DATE: September 8, 2023
FILE NUMBER: MAPN-23-0002 – Karman Line Land Use Plan
RE: Master Plan – 3rd Review
Colorado Springs Utilities
(Mike Gackle, 719-668-8262, mgackle@csu.org)
(Bryan English, 719-668-8119, benglish@csu.org)

KARMAN LINE LAND USE PLAN
 UTILITY EXHIBIT

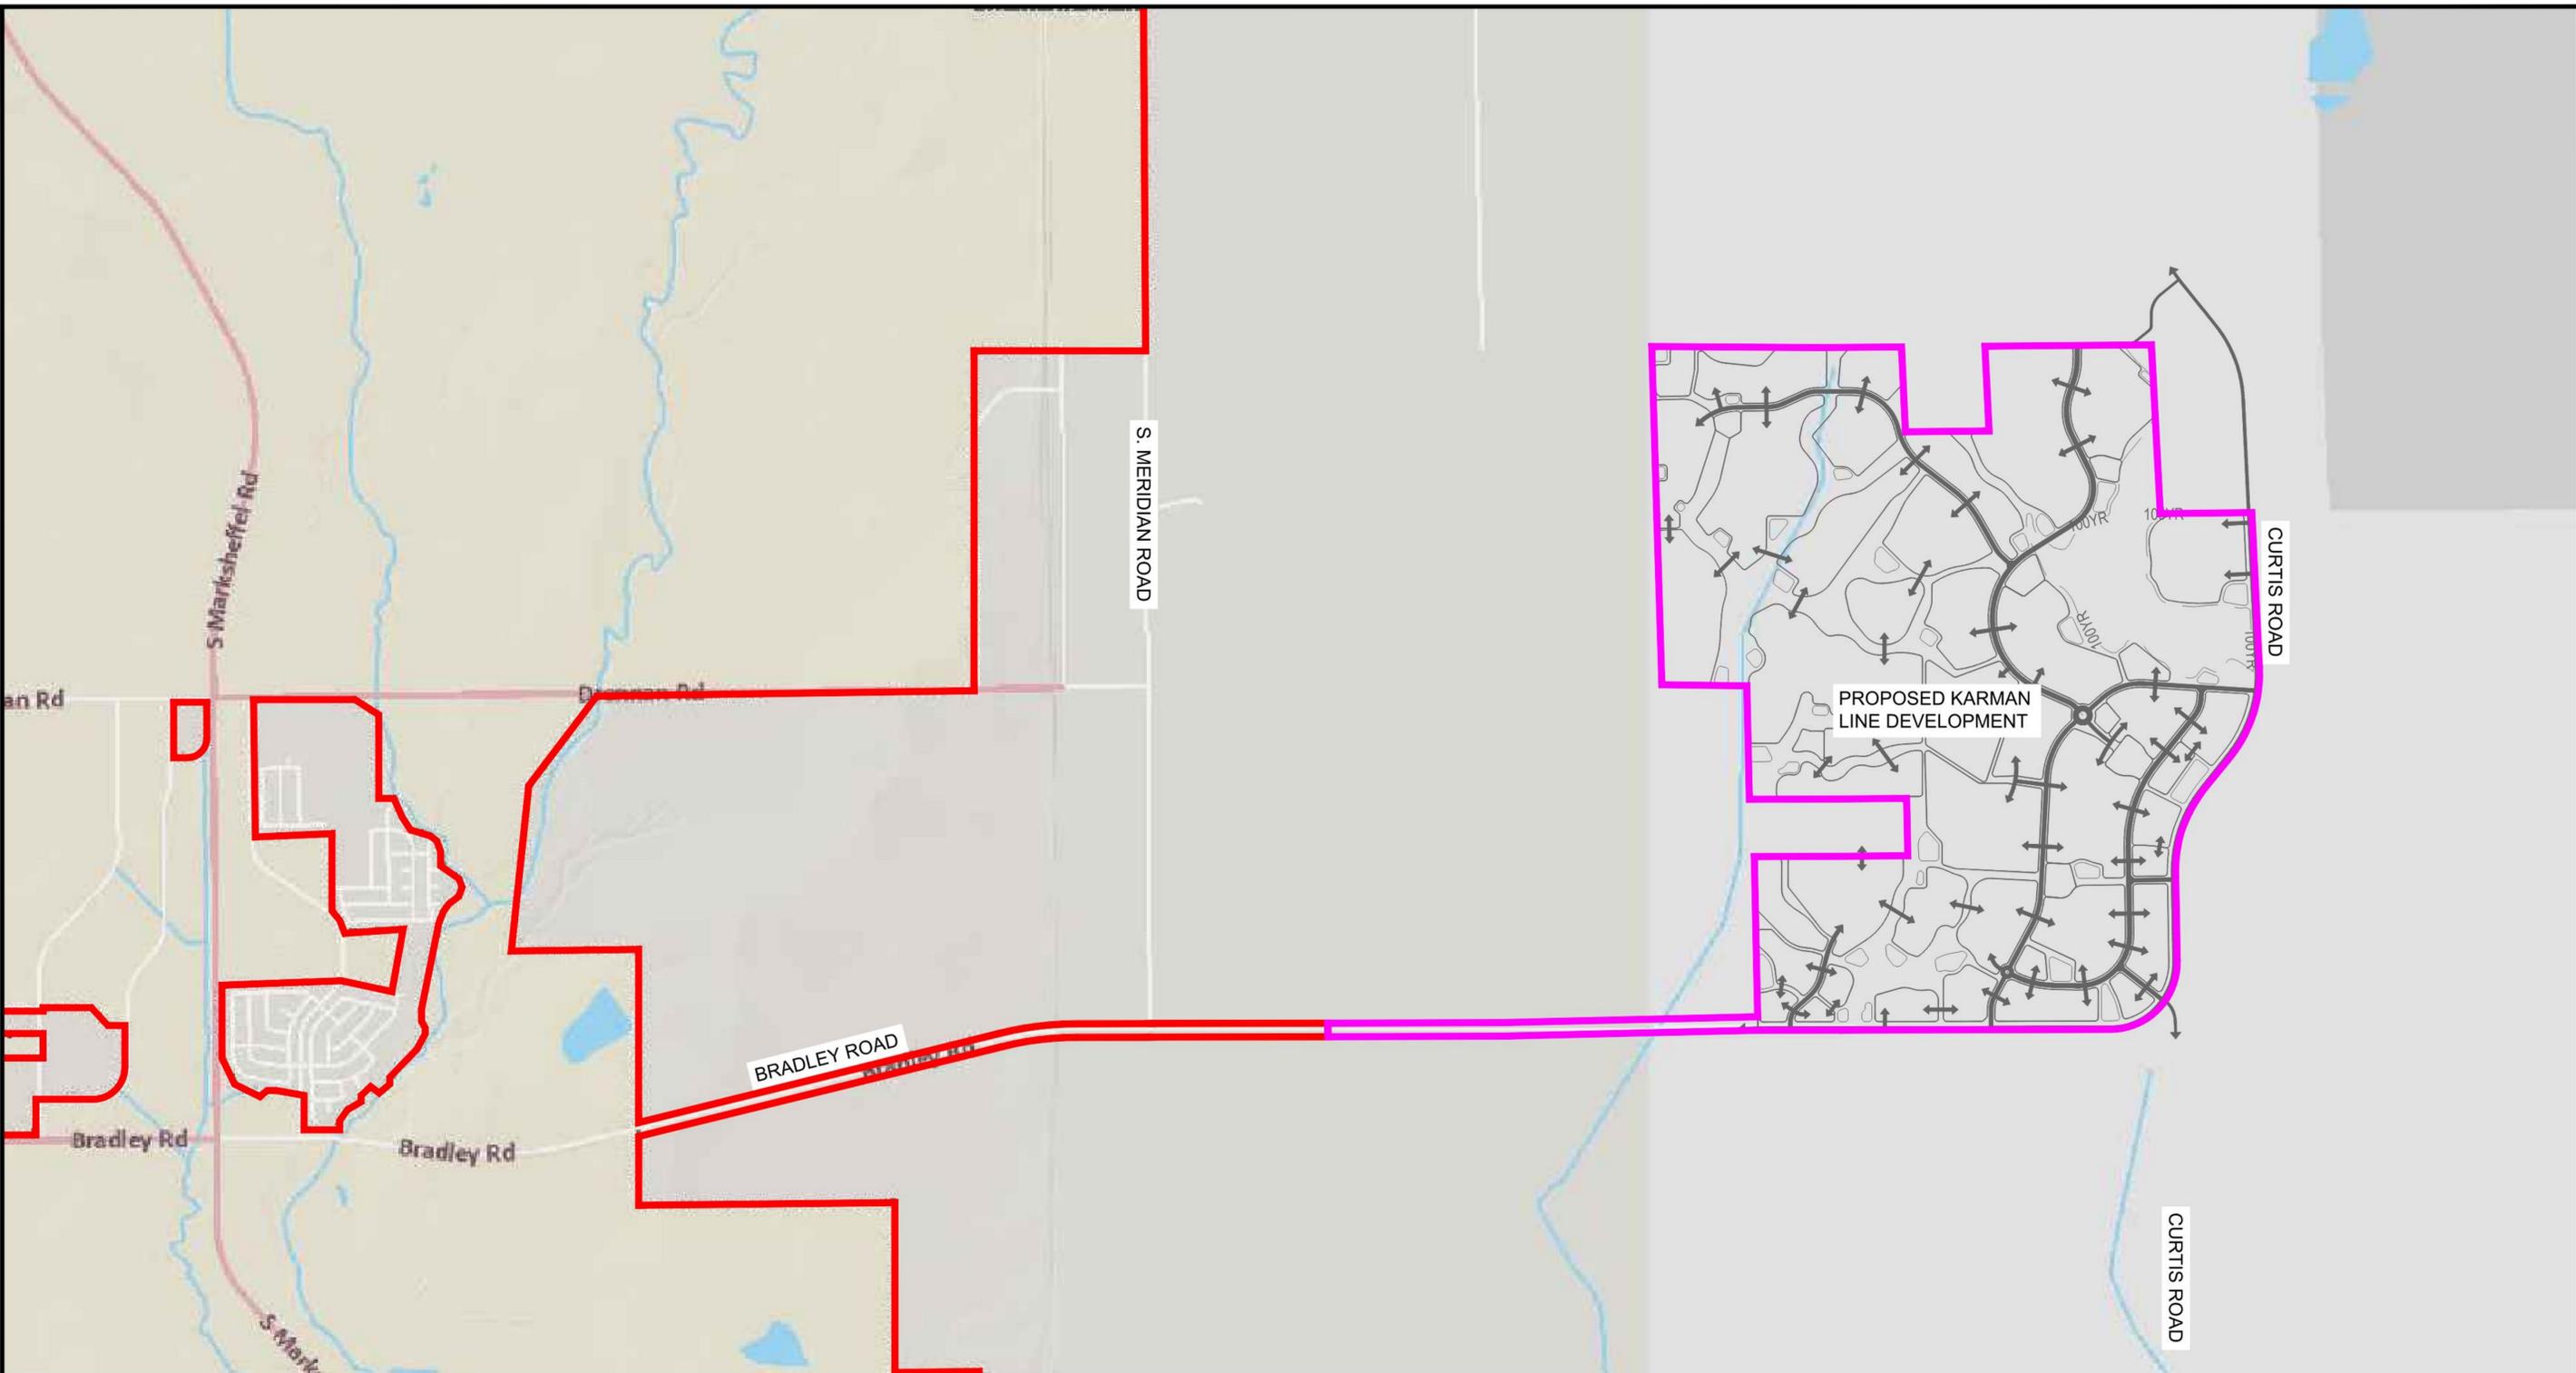
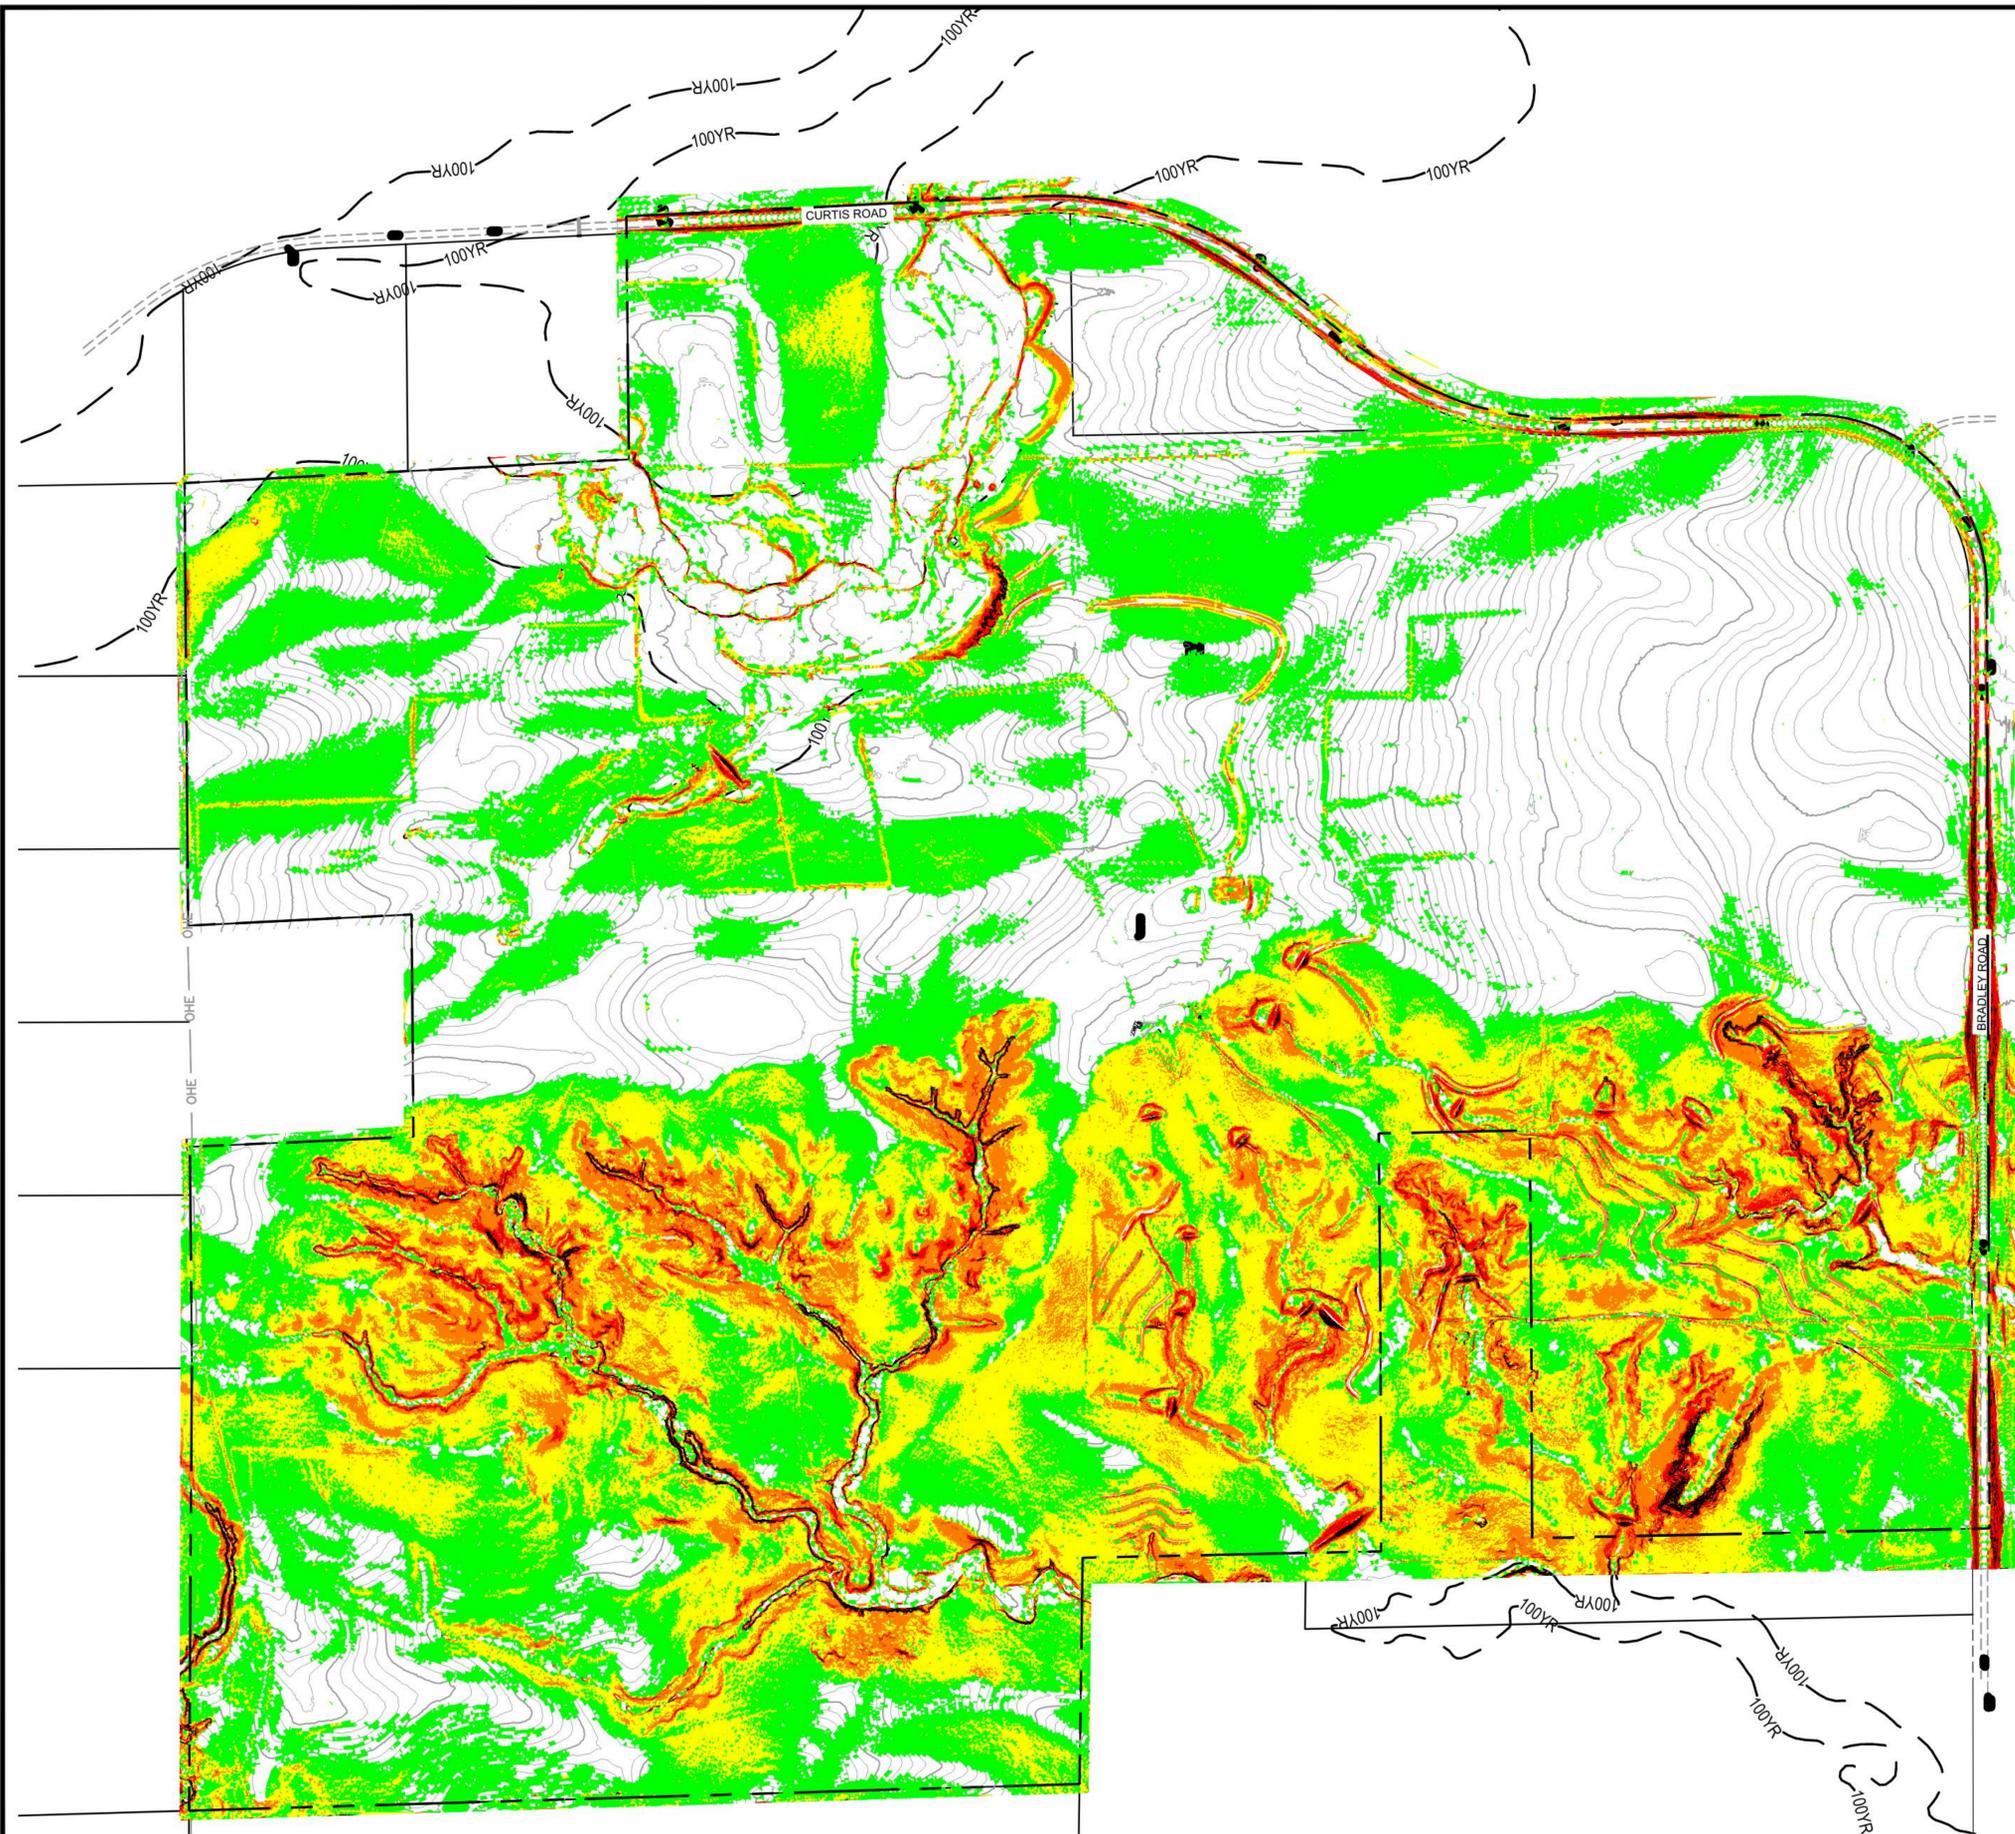
1. Provide Master Utility Plan illustrating proposed primary utility extensions and facilities, including points of connection, routing, alignments and looping, where applicable. For the reason stated below, include wastewater infrastructure to the extent possible; additionally, subject to annexation, provision of a Wastewater Model will be required in conjunction with the first Development Plan.

- Storage tanks are not shown. Storage tank locations to be determined based on continuing analyses. Initial construction would require a temporary hydro-pneumatic pump station which eliminates the need for an initial storage tank. Future tanks would likely be ground storage facilities and owner/developer may be required to dedicate land or acquire sufficiently sized sites to accommodate elevated or ground storage facilities whether located onsite or offsite.

- Pump station location would be coordinated with Springs Utilities Water Planning and must provide both acceptable suction-side and discharge-side pressures, while minimizing additional parallel water mains. Owner/developer would be required to obtain property for the pump station at or near the required location, which is expected to be offsite.

- Attached map shows the location of the proposed Karman Line Annexation in relation to planned wastewater infrastructure. Planned wastewater infrastructure represents the lead alternative from the Banning Lewis Ranch Study and is subject to change – no designs, nor definitive plans have been made at this time to construct the planned infrastructure. Karman Line is envisioned to connect to the planned infrastructure and would pay a pro-rata share of costs for the entire downstream infrastructure to the Las Vegas Street Water Resource Recovery Facility (LVSWRRF).

- There is a future adjustment to the Bradley Road alignment due to completion of the future Gary Bostrom Reservoir that needs to be accounted for in the planned infrastructure routing. The Bradley Road realignment may also impact the southwest corner of the development, potentially trigger revisions to the Land Use Plan, including alterations to planning areas and roadway alignments.

- Owner/developer would extend wastewater infrastructure on the property to serve additional development areas upstream of the planned wastewater infrastructure.

- Lift station(s) and associated force main(s) may be phased (smaller initial phase to larger future phases) to ensure proper operation of the lift station(s) and force main facilities.

- Owner/developer responsible for dedicating land and/or easements via plat and/or separate instrument and/or acquiring land and/or easements for all lift station(s) and force main facilities that are not located in a suitable right of way.

- All gravity wastewater mains, including interceptors, trunk lines and collection lines would be sized for design build-out conditions.
2. Provide a phasing map or exhibit showing the proposed or anticipated development and construction phasing for the entire development.

Item addressed. Please review additional comments below.
